Ribble Valley Borough Council
Planning Section
Council Offices
Church Walk
Clitheroe
BB7 2RA

App No 3/2025/0720

Proposal Proposed demolition of existing holiday let chalet and replacement with one single-storey two-bedroom holiday-let. Alterations to existing access and with replacement entrance gates and fencing and creation of parking area.

Location Hazelmere Longridge Road Hurst Green BB7 9QP

DRAWING TITLE:
Proposed Entrance Elevation

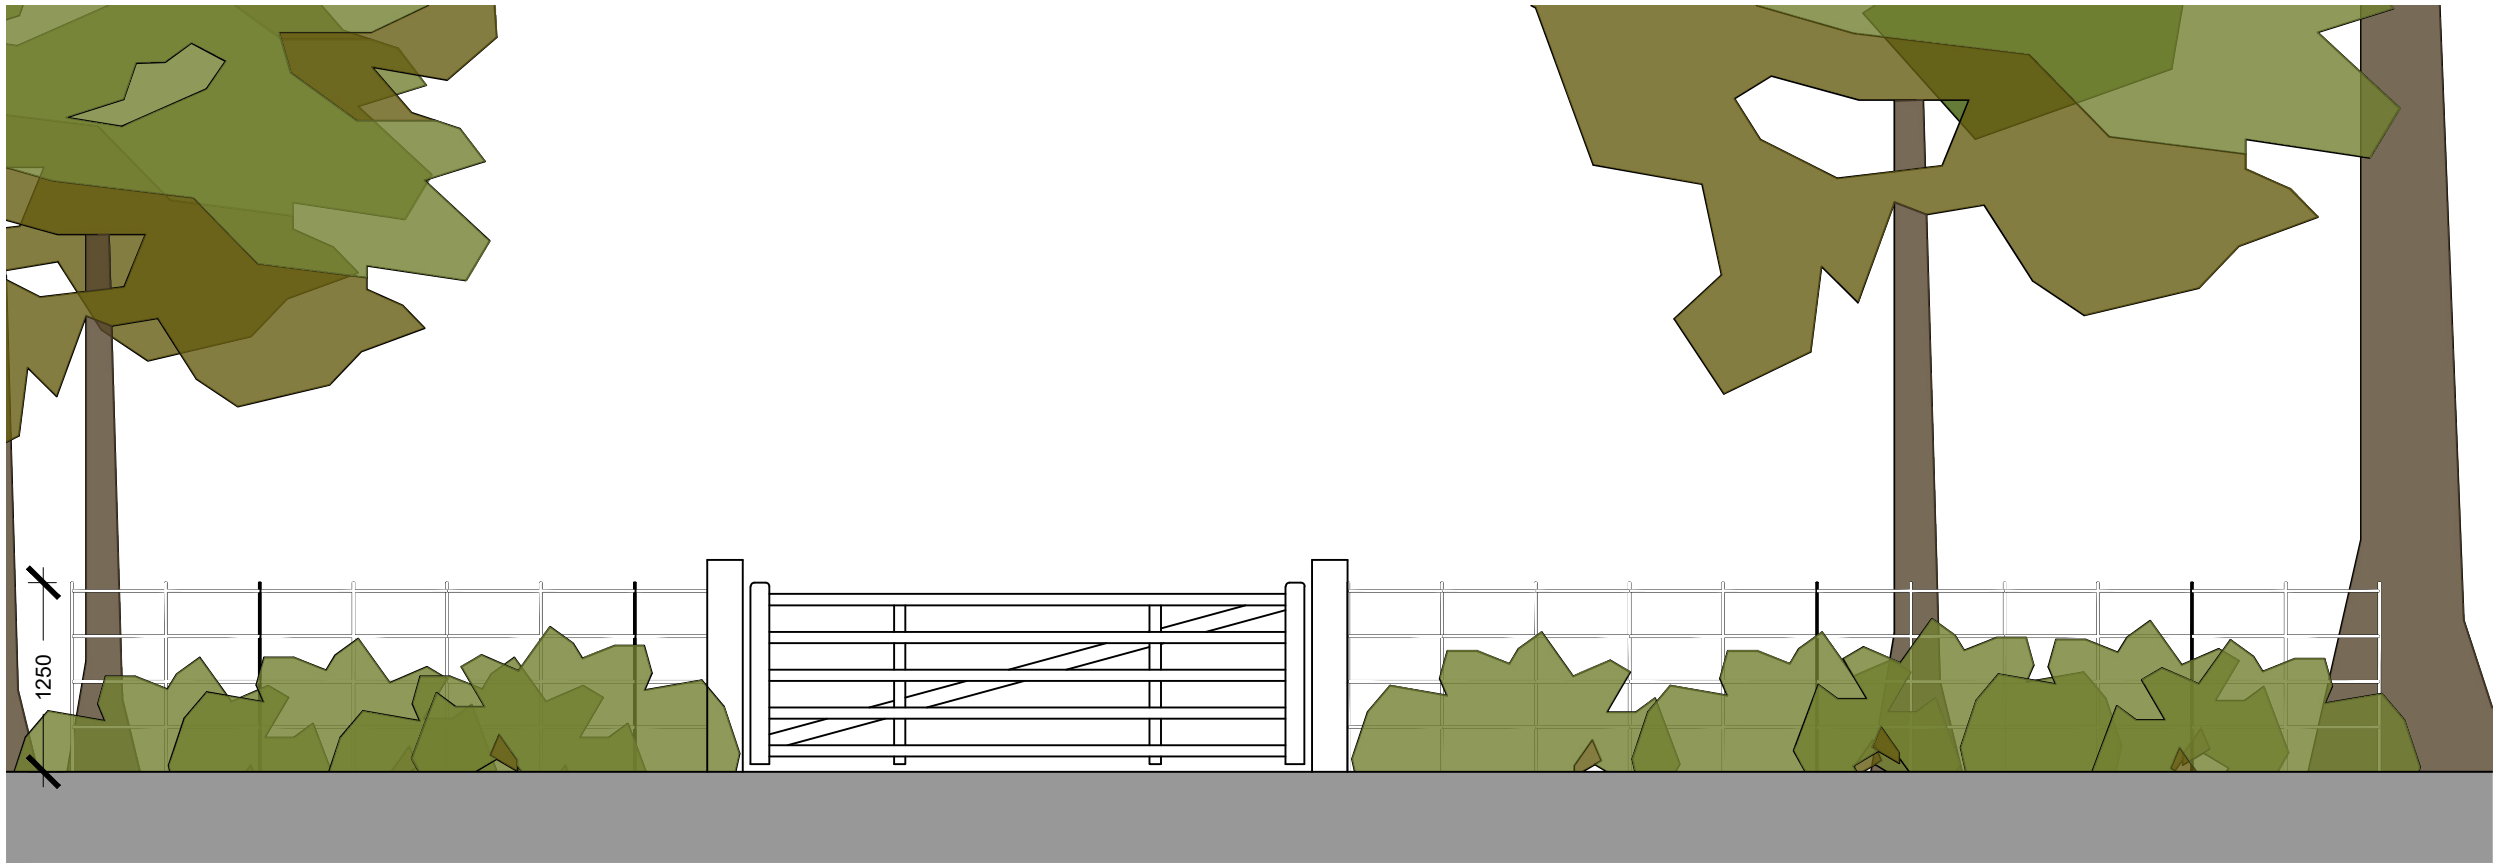
The site access is proposed at a width of 4m between the highway and the parking area and with the radius widened to 6m to allow vehicles entering the site from the west to easily transition into the access from the 40mph speed limit classified road for highway safety reasons.

The gates are set back by 5.6m and this is considered acceptable. The site access for at least the first 5m should be paved in a bound and porous material. The surface water is proposed to be drained and outfall to the Bailey Brook. The applicant should ensure that they have a permit for the drainage works.

Lancashire County Council acting as the Highway Authority would request that the site access is widened as stated above. Subject to this there is no objection to the proposal. Should the application be approved there are a number of conditions are requested relating to the site access and visibility splay mitigation measures.

2. Prior to first occupation the site access shall be constructed in accordance with the submitted details and shall be paved in a bound and porous material for at least the first 5m from the edge of the carriageway (see informative note).
